Replacement Boundary Wall to Southern Boundary of Property

Replacement Wall 11/12 Cross Street

TITLE
**PROPOSED
 REPLACEMENT WALL
 SECTION AND DETAILS**

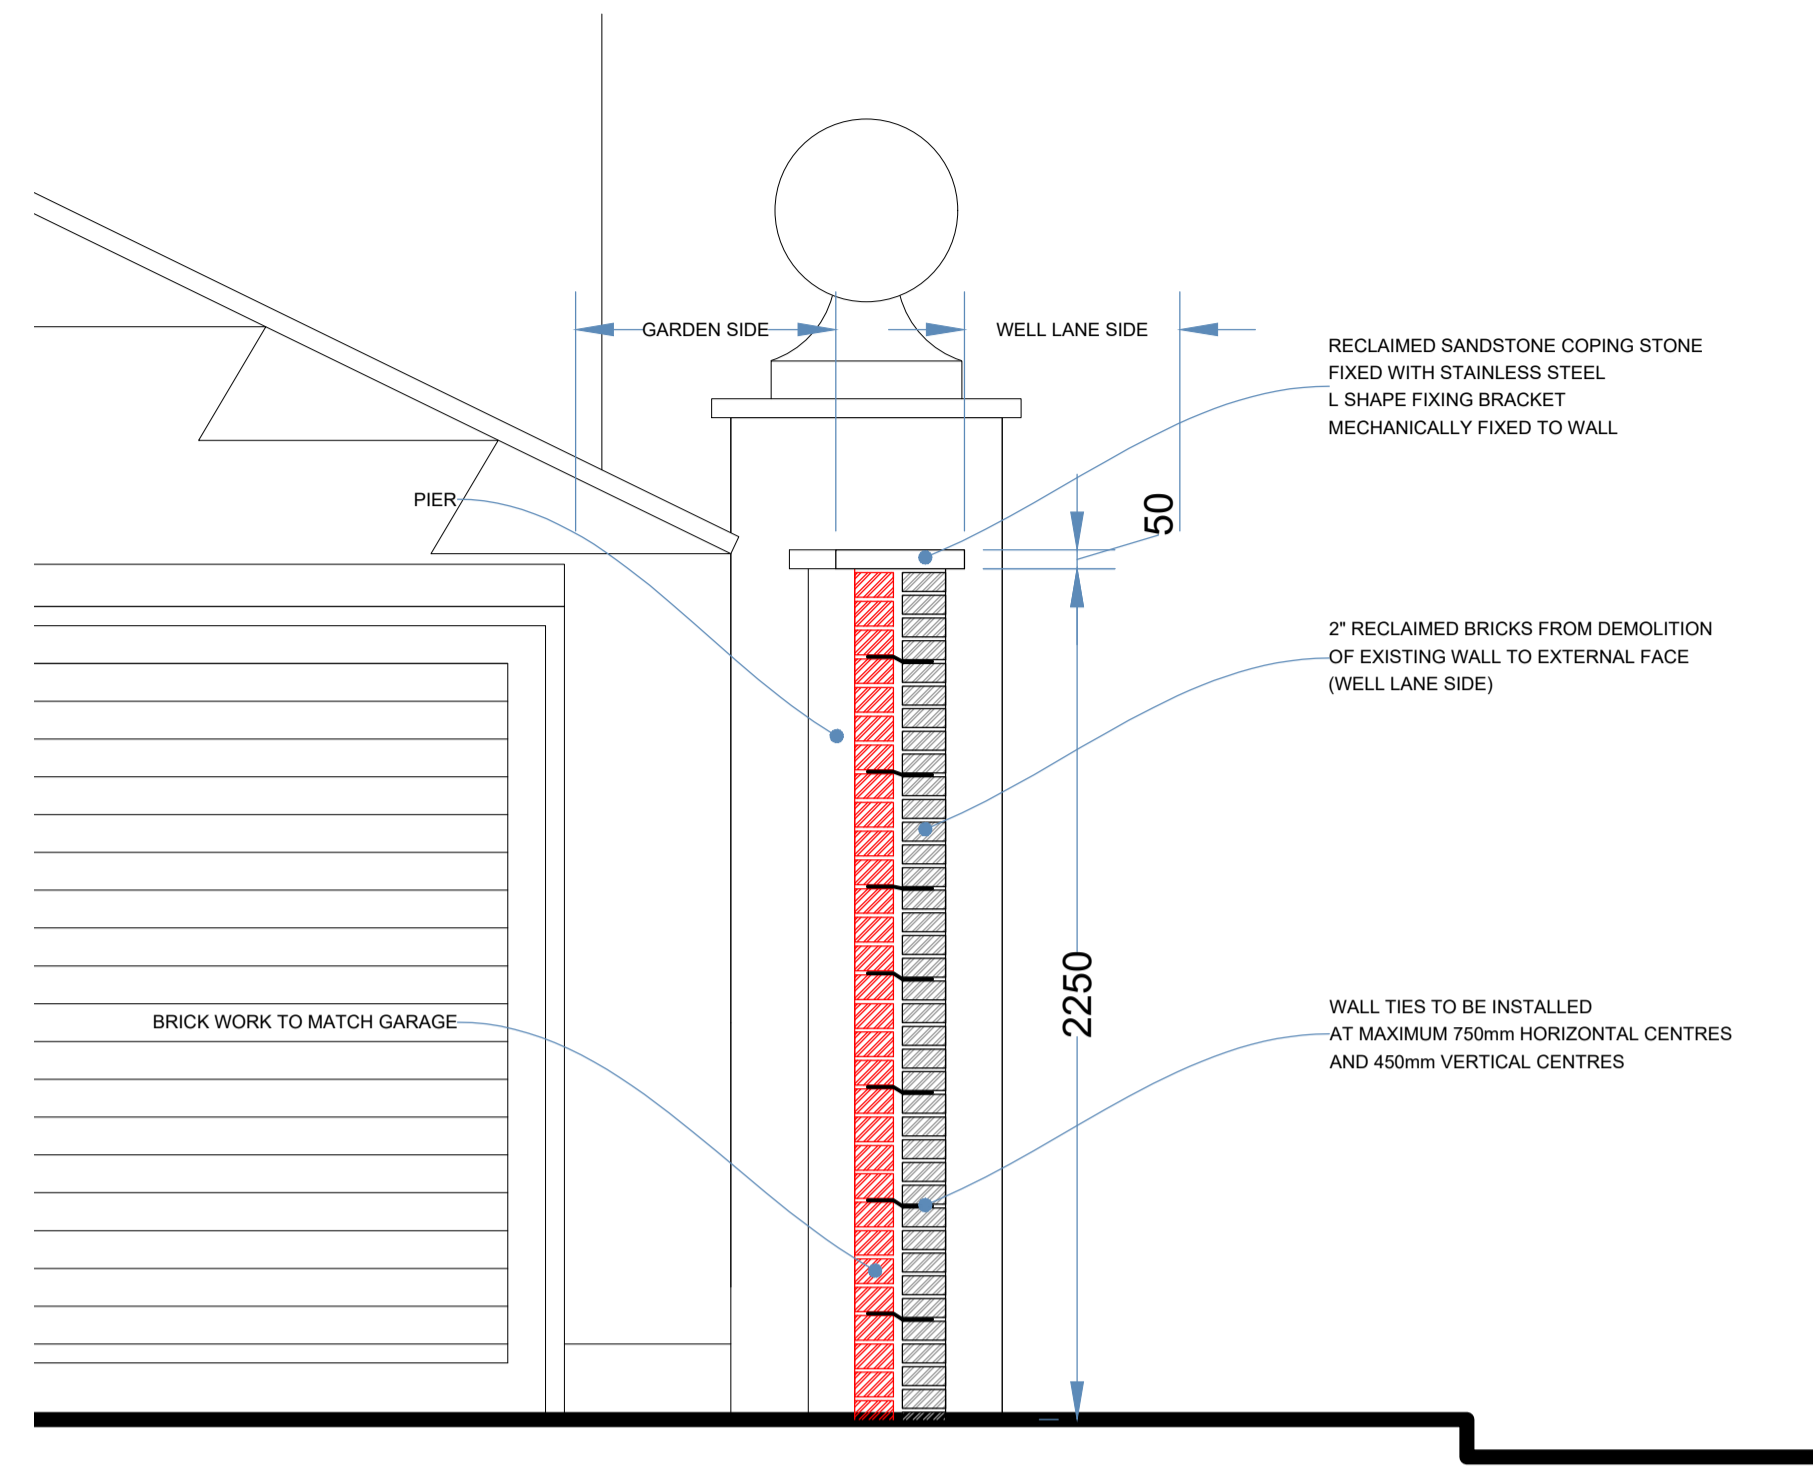
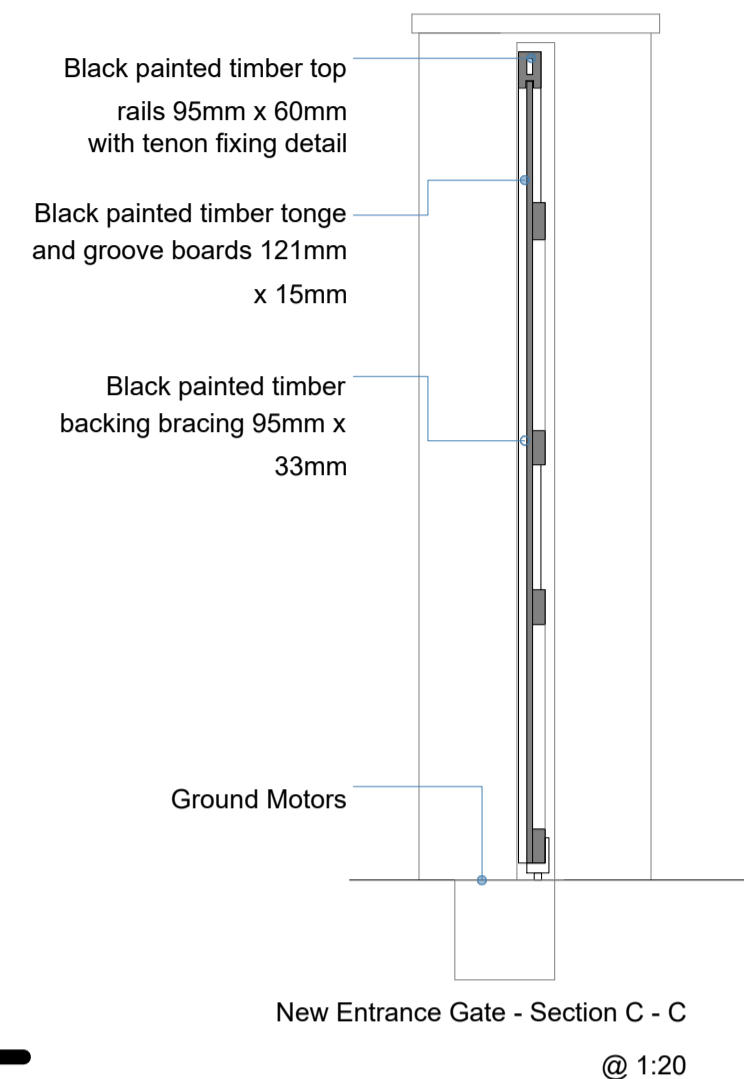
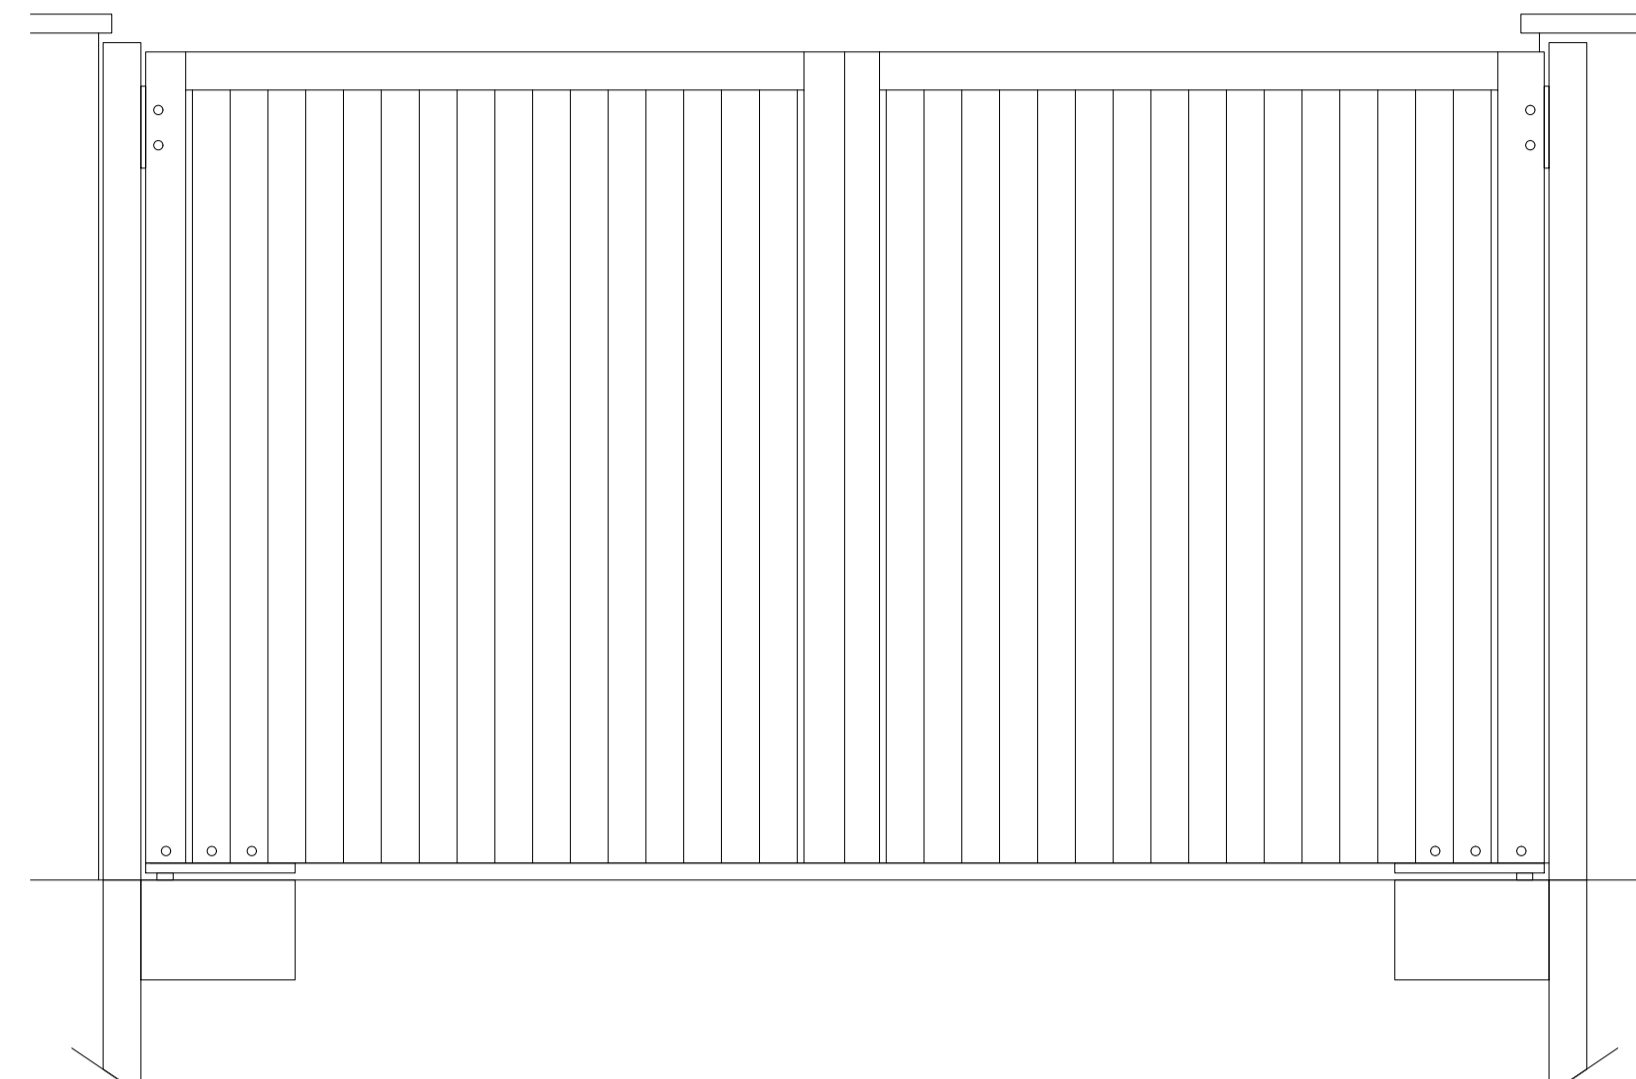
- 1) It is proposed to install stone coping at the top of the wall- was this in situ when the wall came down, or proposed to be introduced because it would be to the benefit of the long term construction of the wall?
- 2) I see that the proposed gate details appear to match those proposed as part of the previous 2021 approval on the site- can you confirm this is the case?
- 3) We will need a supporting method statement with any application, which should include the necessary specifications for elements of the works such as mortar mix and pointing profile. We would also want to see a sample of a new brick.
- 4) You will also need to look through our validation requirements to make sure that you are including all the additional information they are going to need before they can validate it (location plan, heritage statement etc.)
